From: Maria Tomalova <Maria.Tomalova@arun.gov.uk>
Sent: 15 September 2020 13:07
To: Planning.Responses <Planning.Responses@arun.gov.uk>
Subject: FW: FW: BR/188/20/DOC -

Please upload the below to the above application: Drainage Engineers comments

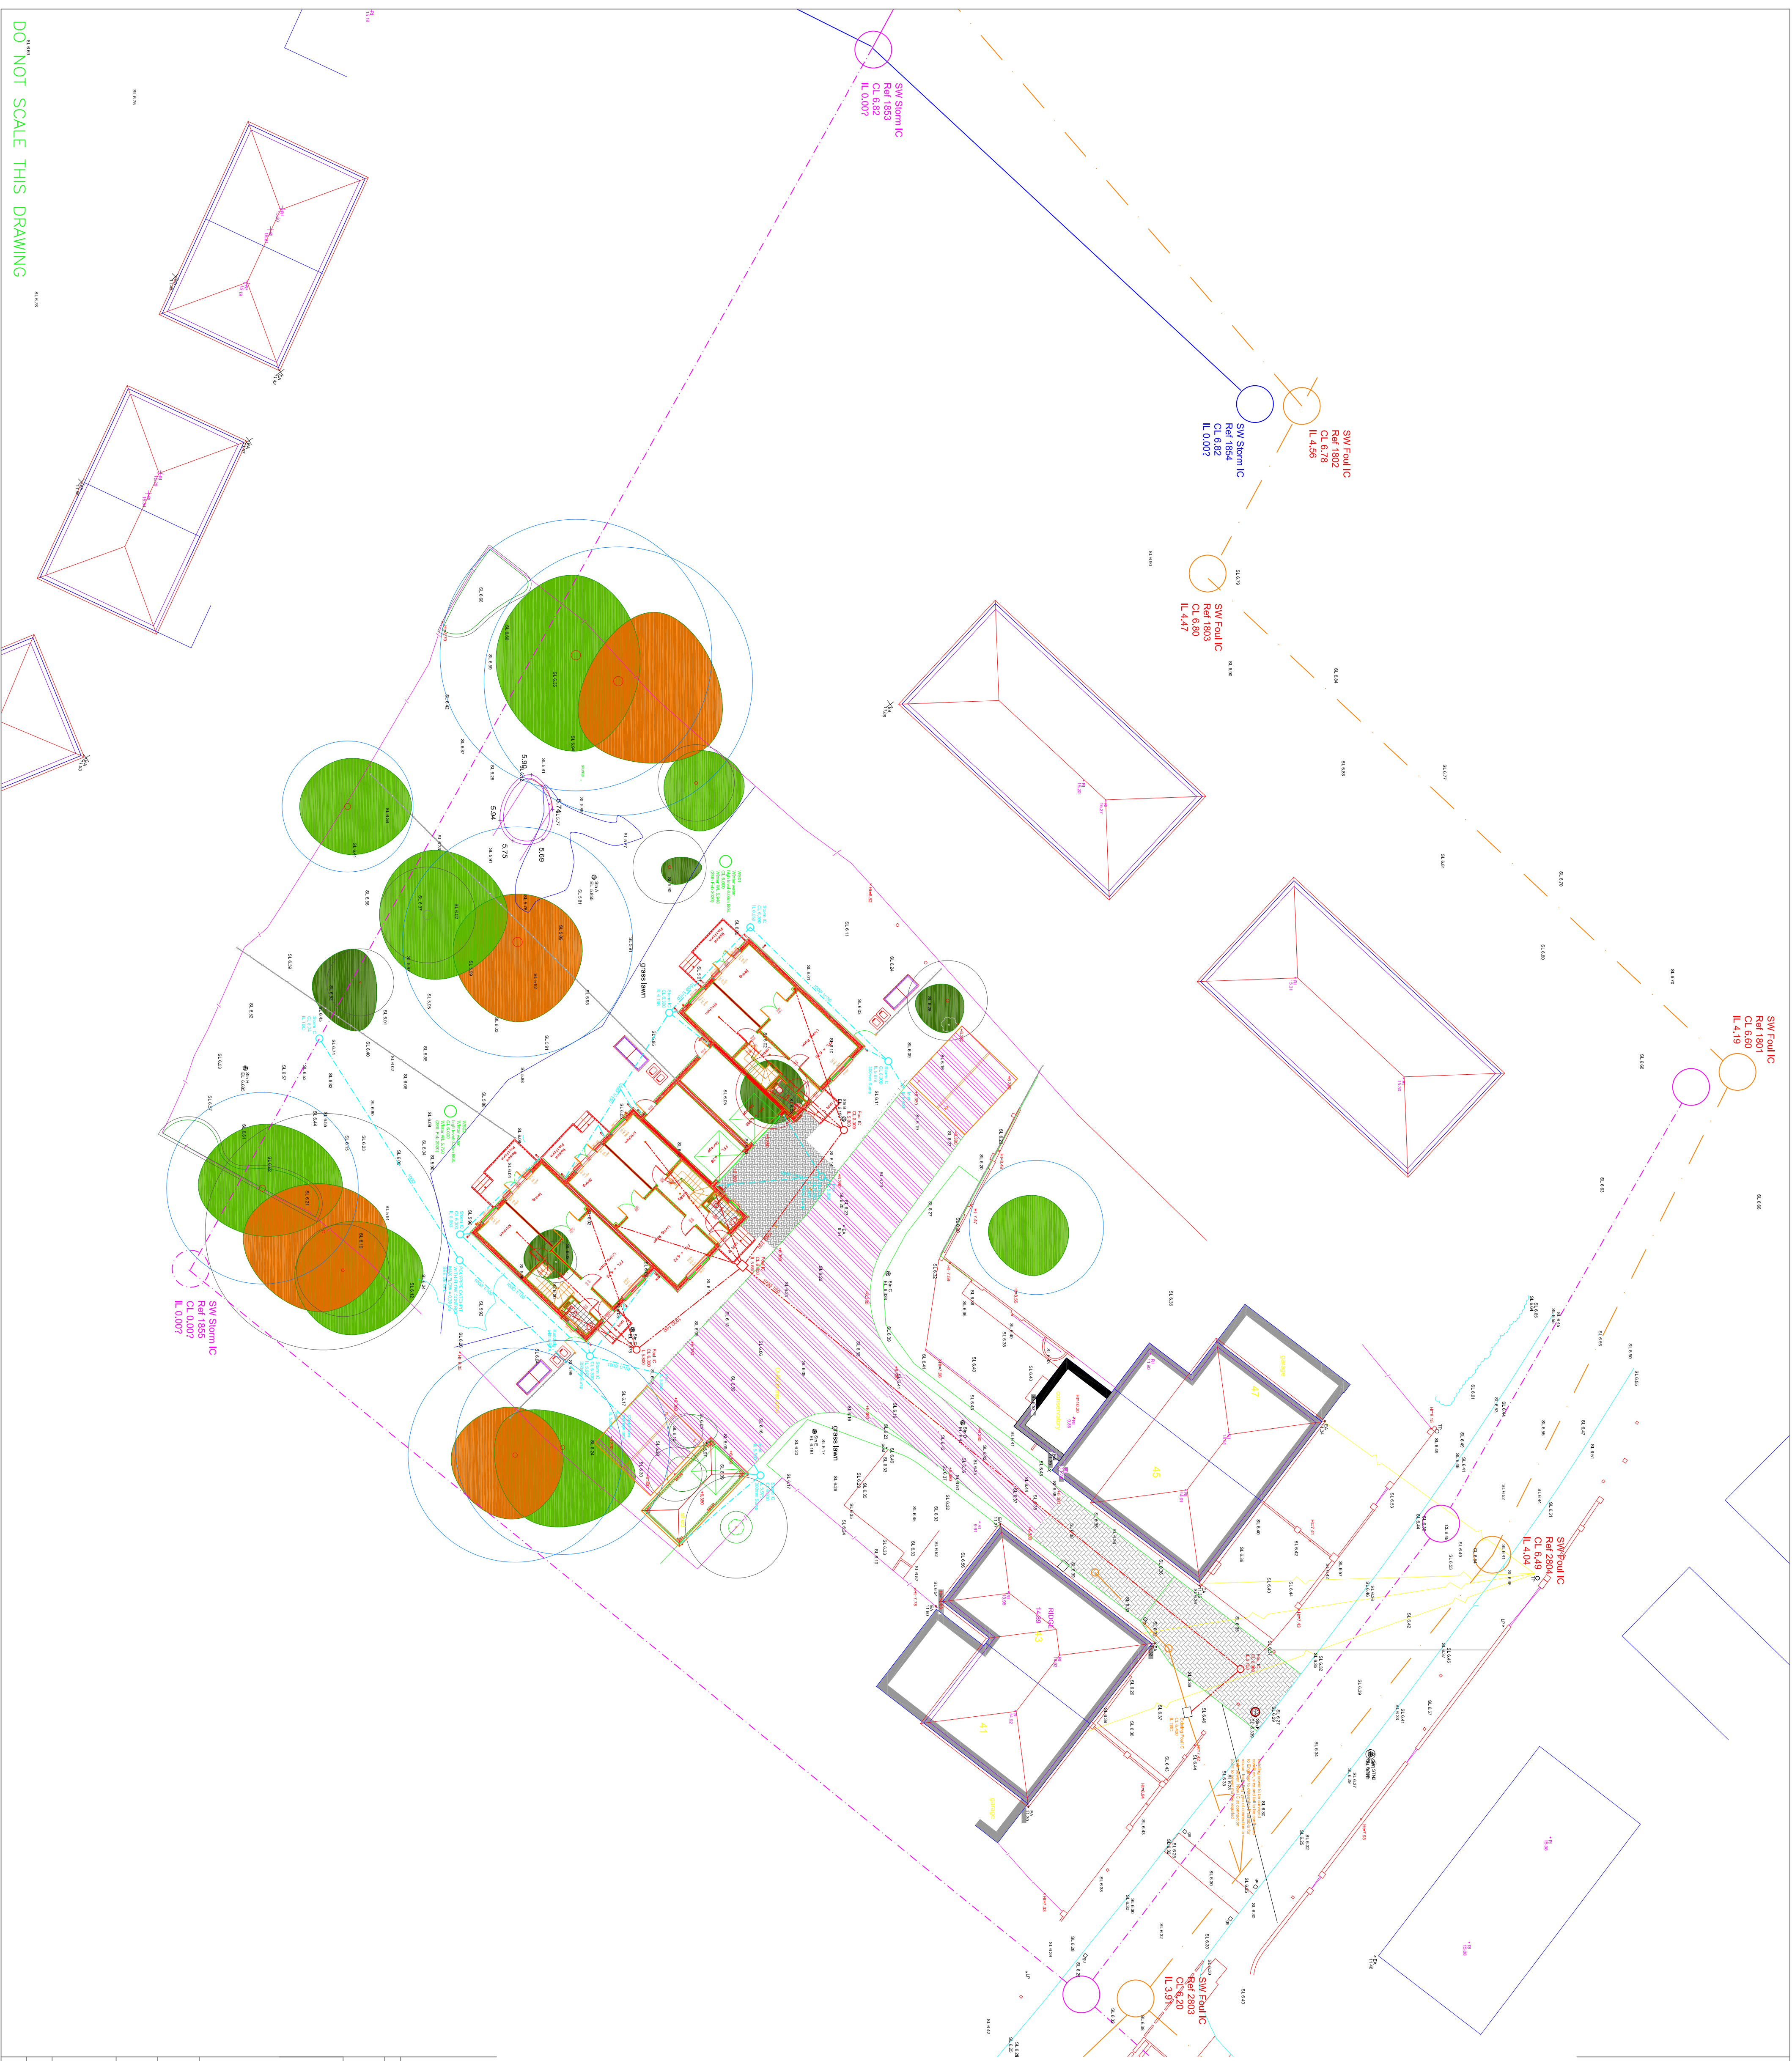
On this occasion we will let you complete an attenuation design as we believe it is unlikely that groundwater levels will be sufficiently lower where the permeable paving is proposed. However, please note for future applications that testing must be completed at the location of the proposed drainage features.

Permeable paving to the parking area must be provided to allow water to flow through the carport area. It was established with Robert Clark that without this flooding could be increased off site. We do not wish to see water flowing under the habitable accommodation itself.

Thank you for your email. I will update our plans regarding the carports and reissue. Thank you for reconsidering the testing requirements.
